Re: Saddlehorn Ranch, Filing No. 2 (File # SF2133) - 2nd Letter
a.k.a. 824 Acre Curtis Road Subdivision
Parts of Sec. 3 and part of the N ½ N ½ of Sec. 10, Twp. 13S, Rng. 64W, 6th P.M.
Water Division 2, Water District 10
Upper Black Squirrel Creek Designated Basin

We have reviewed the March 2, 2022 referral concerning the above-referenced proposal to subdivide 176 acres (of which 132 acres will be developed) located in Sec. 3 and the N ½ N ½ of Sec. 10, Twp. 13S, Rng. 64W, 6th P.M. into 42 single-family lots of approximately 2.5 acres each. This office previously provided comments on this filing on October 11, 2021.

SADDLEHORN RANCH -
FILING 2
POND #1 GRADING PLAN

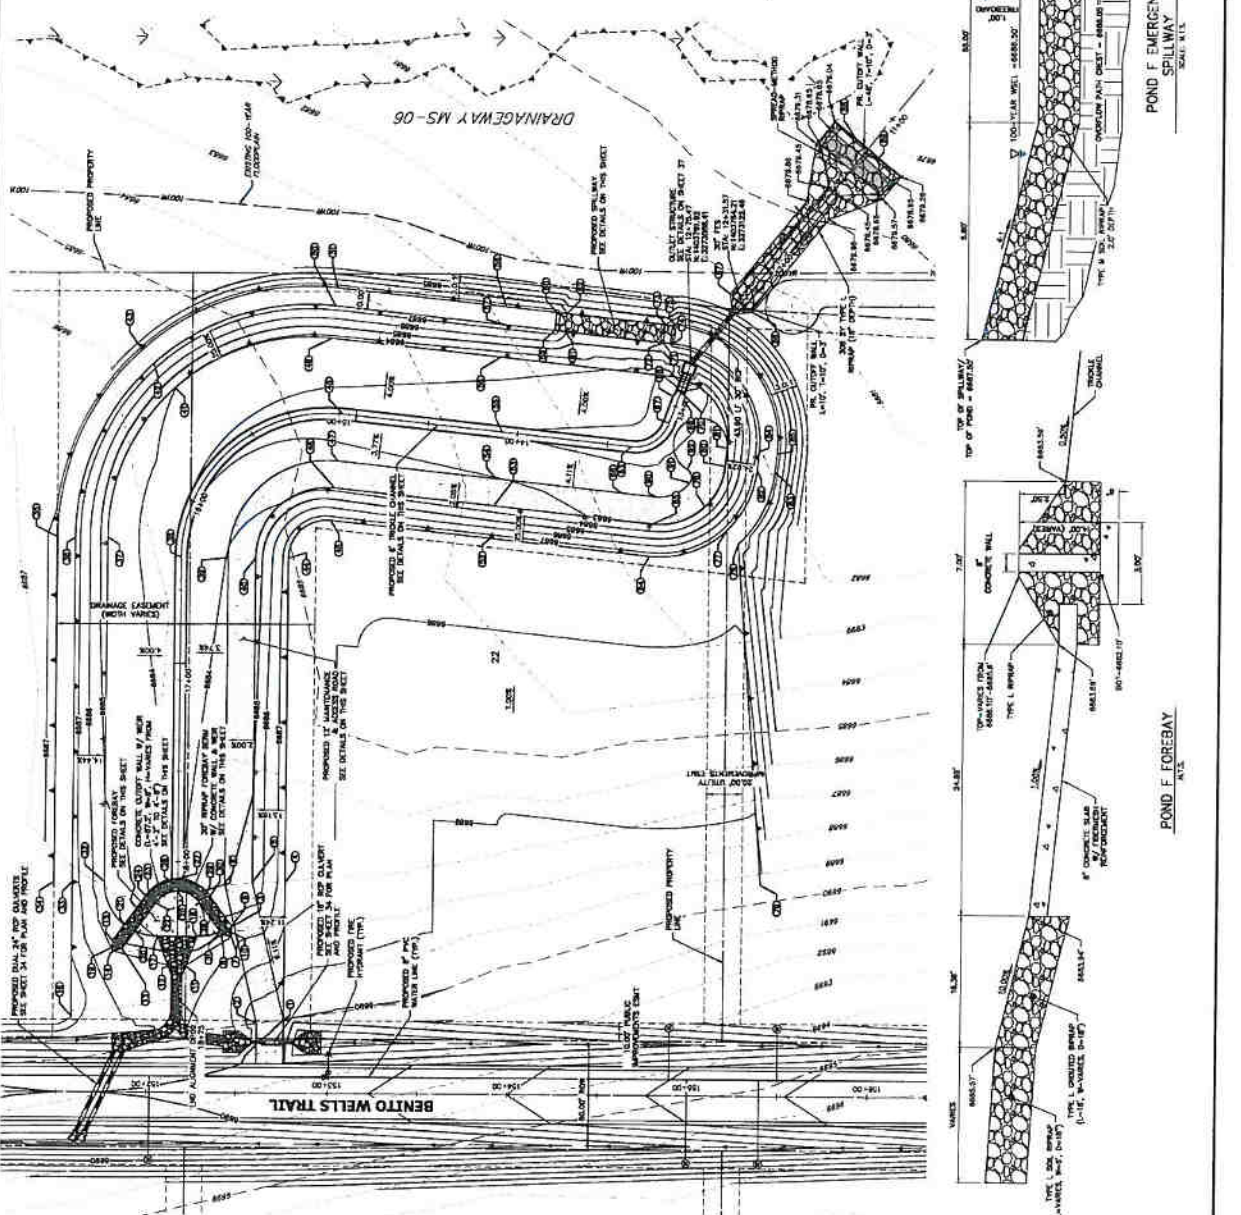
According to the submitted material, storm water detention structure(s) will be developed on the site. The applicant should be aware that, unless the structure can meet the requirements of a

“storm water detention and infiltration facility” as defined in Designated Basin Rule 5.11, the structure may be subject to administration by this office. The applicant should review Rule 5.11 to determine whether the structure meets the requirements of the Rule and ensure any notification requirement is met.

Additionally, the letter of intent stated that water quality control ponds will be developed throughout the subdivision to mitigate impact to the wetlands. Construction details and liner information for the ponds were not provided. The ponds must be constructed in accordance with Colorado laws. If the ponds do not meet the requirements of a “storm water detention and infiltration facility” as referenced above, then such ponds would be subject to administration by this office. Additionally, the ponds would not be allowed to expose groundwater to evaporation without first obtaining a Commission approved replacement plan adequate to prevent any material injury to existing water rights.
